Application: SSI 7485

I write regarding the proposed modification to M4-M5 Link, Mod 2 The Crescent overpass and changes to pedestrian infrastructure in North Annandale, Rozelle and Rozelle Bay Foreshore area.

Figure 4-2 Pedestrian and cyclist bridge infrastructure options

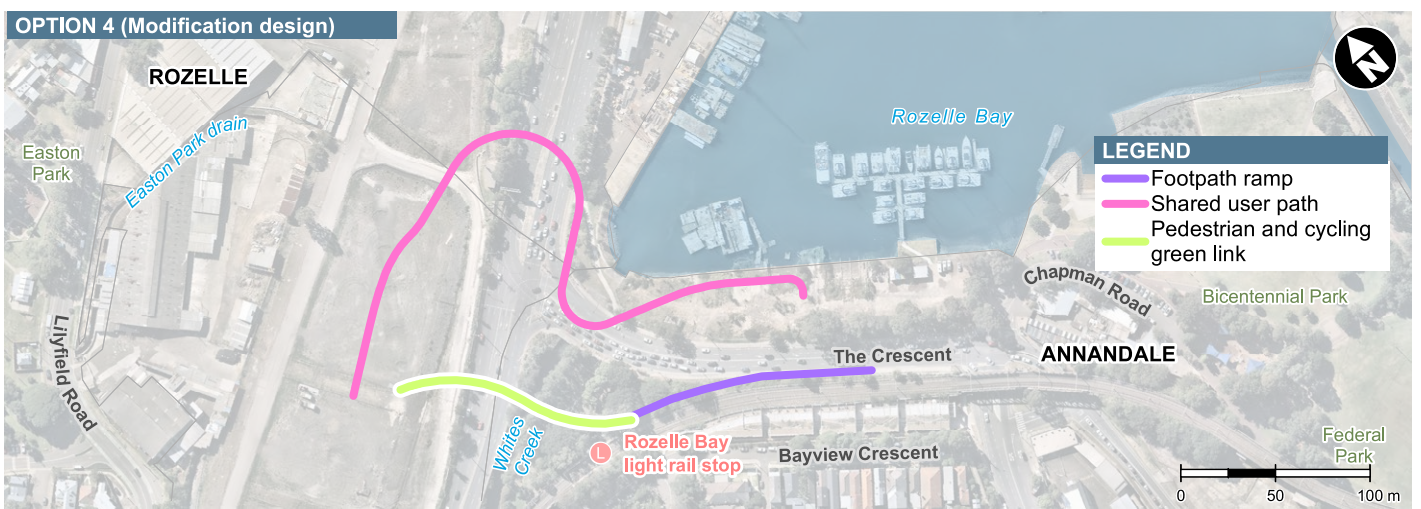
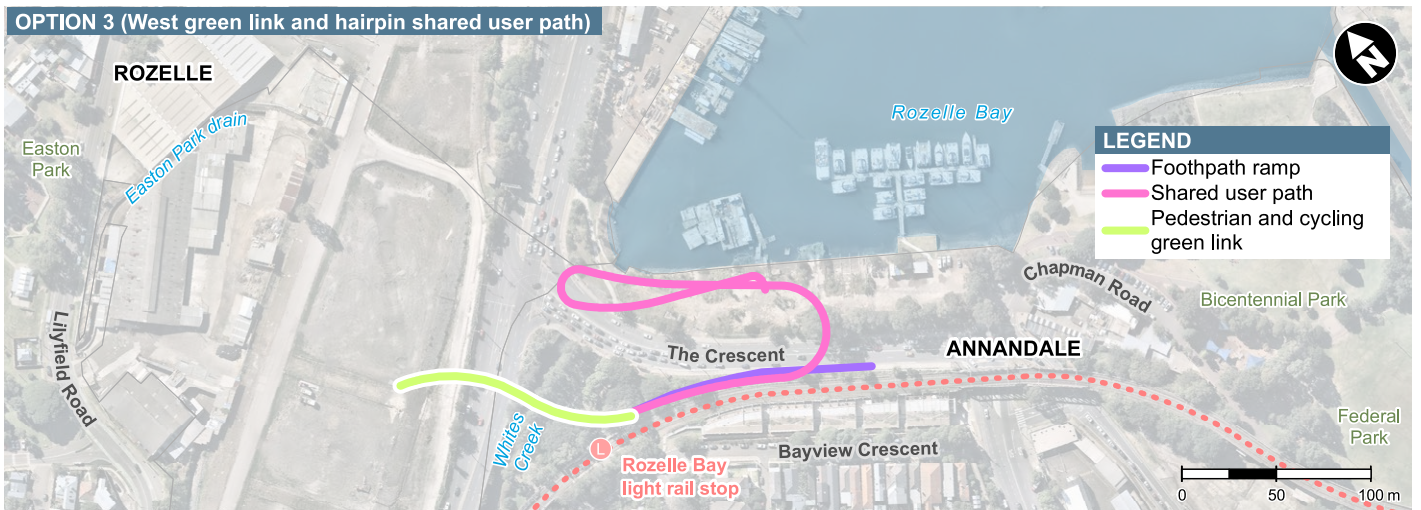
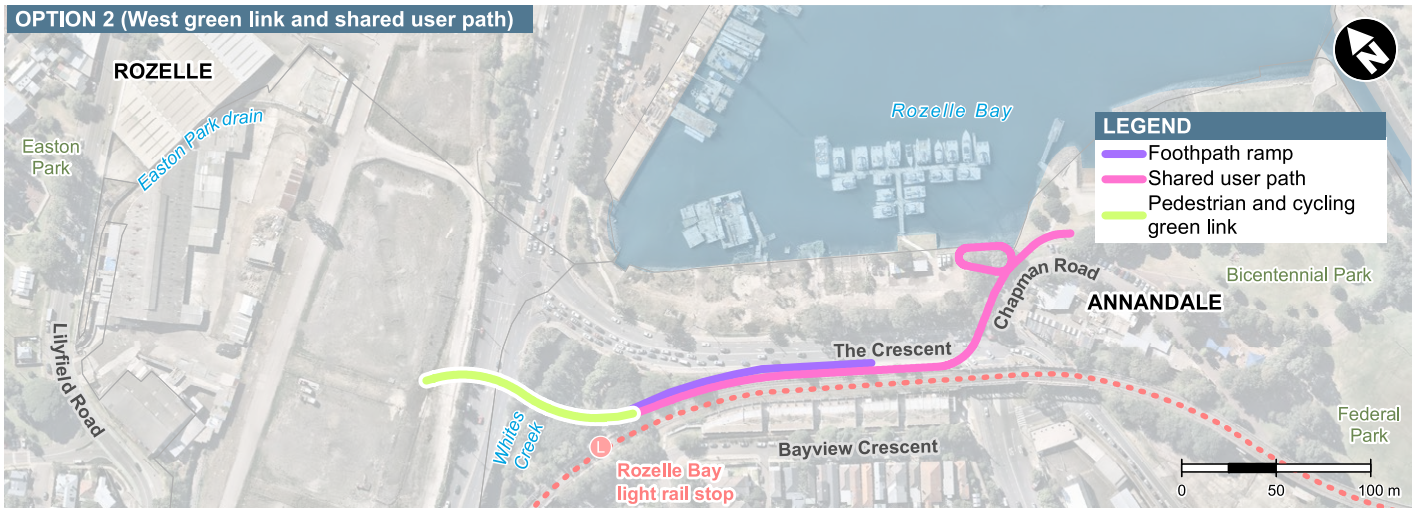
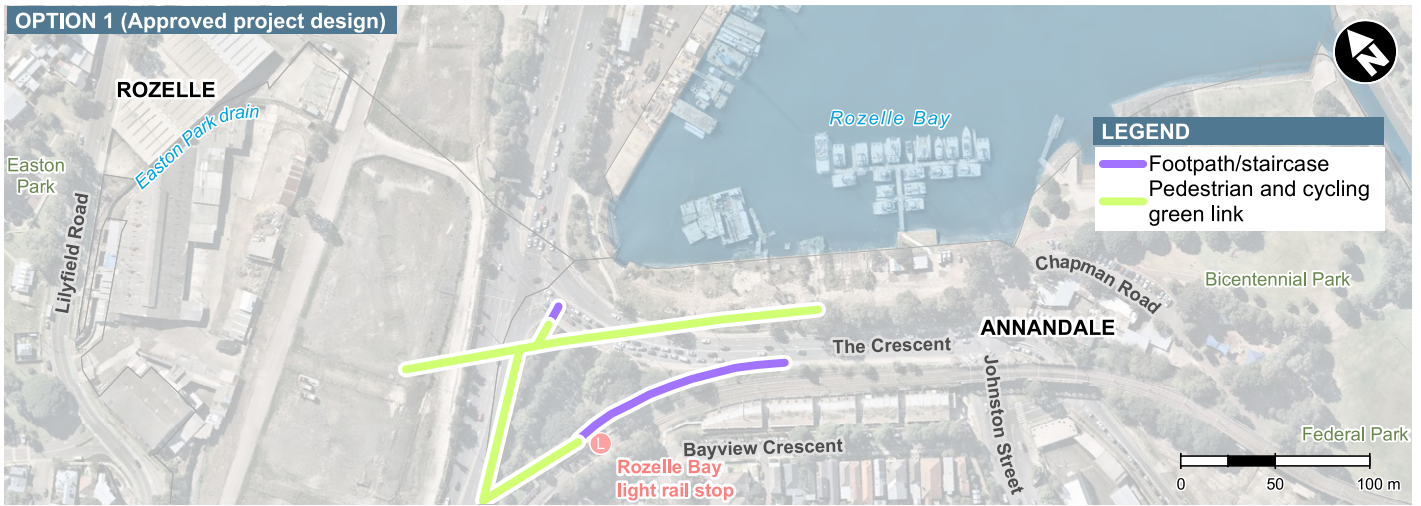
I request RMS work with the community to explore alternative design options to the proposed new car overpass design and the changed pedestrian and cyclist links. I am seeking the reinstatement of the safe, direct access from the approved EIS GreenLink to create a continuous green open space connection from the Rozelle Rail yards and Annandale to the foreshore. The GreenLink was more than just a walkway - it put people central to the design, maximising safety, and providing much needed accessible open space for the community now and into the future Bays Precinct design.

- The significantly reduced safety and increased risk for pedestrians and cyclists with removed access over The Crescent to Bicentennial Park and the increased traffic along Johnson Street.
- Being required to cross five sets of pedestrian lights at The Crescent as my option to reach the foreshore from Annandale or from Rozelle Bay light rail stop.
- Removal of direct active links to the foreshore, cutting the community off from the area and the proposed revitalisation of the entire Bays Precinct, including linking the Light Rail and Bus stops to a Ferry wharf and Metro station.
- Urban and landscape design that is being built before a finalised Masterplan for the area.
- Traffic changes that limit movements around the suburb and create further congestion in the local streets of Annandale, Forest Lodge, Glebe, Lilyfield and Rozelle with no planning to deal with these.

- Reinstatement of the GreenLink connecting communities and green open space from Rozelle to Bicentennial Park
- Relocate and design pedestrian and cyclist connections that are continuous, safe and direct.
- Design the modification infrastructure and active links in response to the character of the suburbs, the location of the foreshore and its potential future development.
- Provide pedestrian and cyclist paths that maximise people safety and do not force them onto busier streets, unsafe concrete plazas and caged walkways.
- Integrate active and direct connections to all active transport – including the future Metro West and Foreshore Ferry Wharf
